From: Joe Russell-Wells <Joe.Russell-Wells@arun.gov.uk>
Sent: 12 January 2022 16:37
To: Michael Eastham <Michael.Eastham@arun.gov.uk>
Cc: Robin Wickham <Robin.Wickham@arun.gov.uk>
Subject: RE: A/235/21/DOC - Land At Arundel Road, Angmering - revised Design Code

Please find attached the revised **Design Code Rev. C** for **A/235/21/DO** for Land at Arundel Road, Angmering.

Proposed land use plan

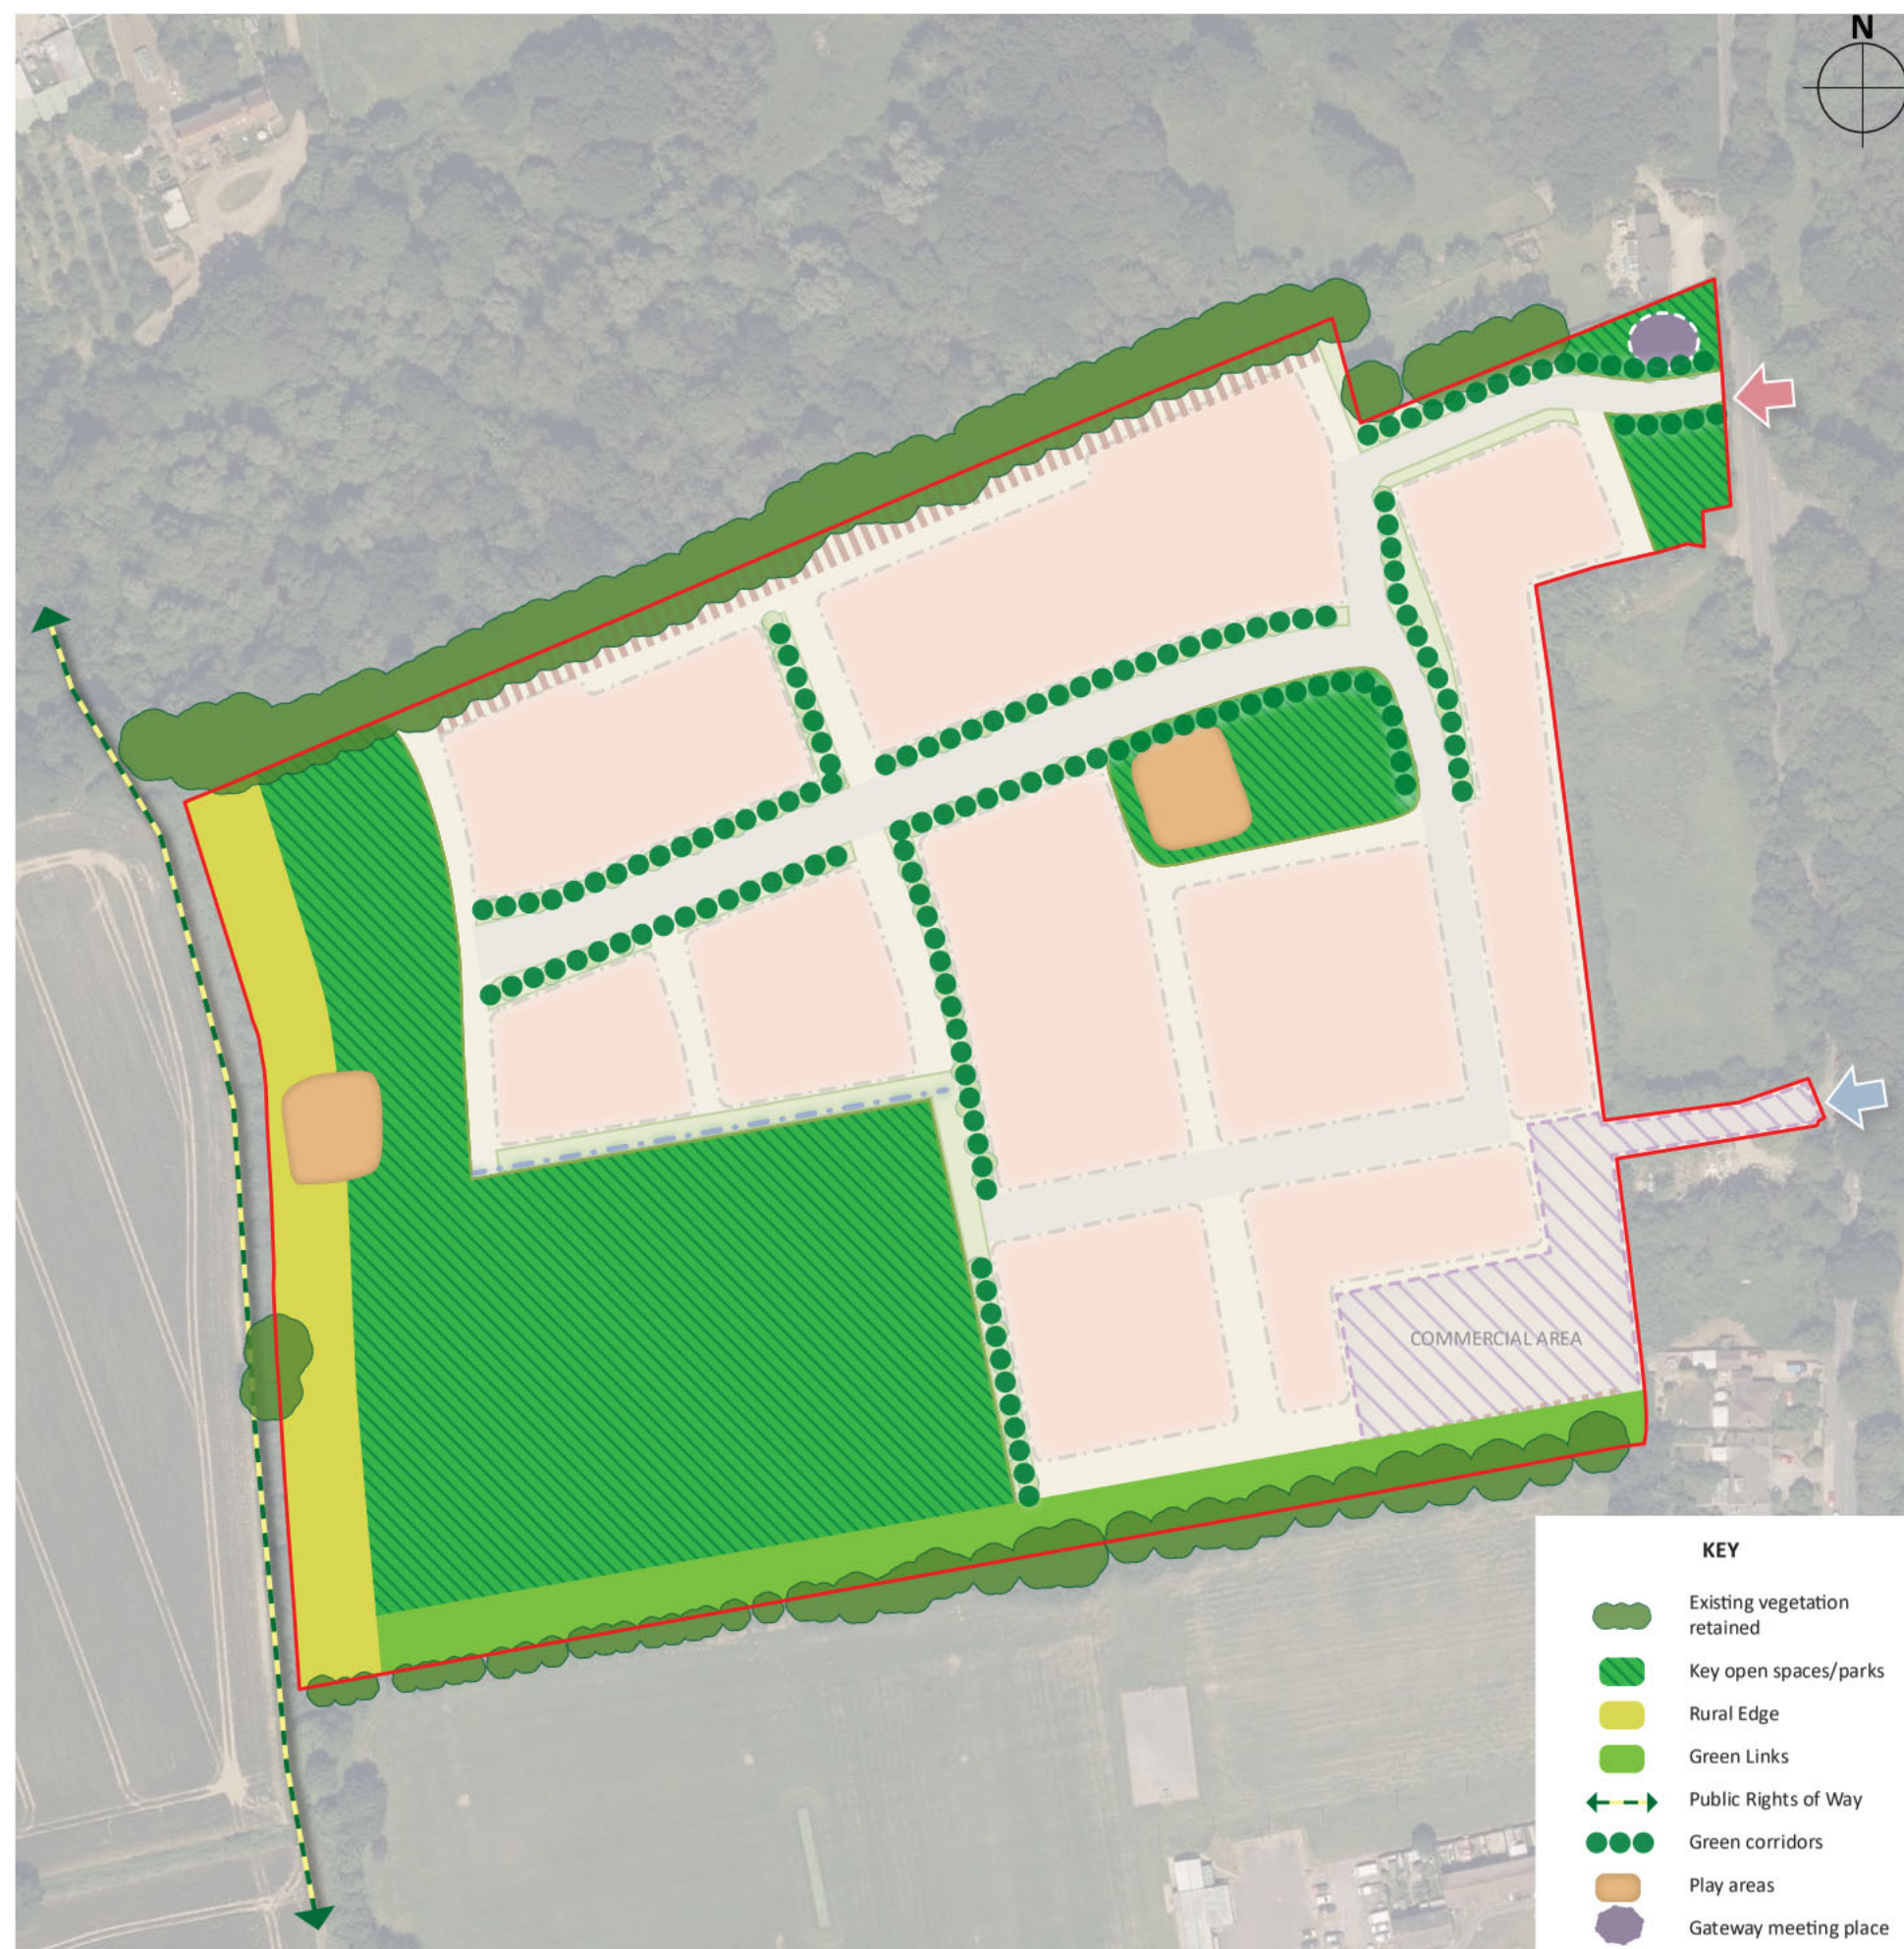
On page 23 and 24 there is some disparity on the land identified as the sports pitch land compared to page 22. They appear to show the same area of land as both green infrastructure (page 23) and as part of the key open space / parks (page 24). Although there is overlap between the definitions used clarity over the area of land to be used as sports pitches should be identified throughout. It is acknowledged that at the stage the DOC was submitted the pitch layout had not been determined, however to identify the land as

anything other than sports provision is potentially misleading. In addition whilst the document refers to the area to the south as being sports pitches, it does not refer to this being transferred to ADC and being integral to the existing sports site to the south.

In order to be clear and open as to the future use of the sports pitch land, and as is set out in the S106, there should be reference to the land being transferred to the local authority and added to the existing recreation ground for future use for sports – there are several opportunities to reference this that have been missed. Anything else in the design code is potentially misleading to the community.

The document has been amended to reflect the comments which identify the green infrastructure and sports pitch and has made refers to the definition of the S106 this is therefore satisfactory. It has not addressed the transfer of this land to the local authority, however this may not be judged to be important as part of the design code and therefore this DOC.
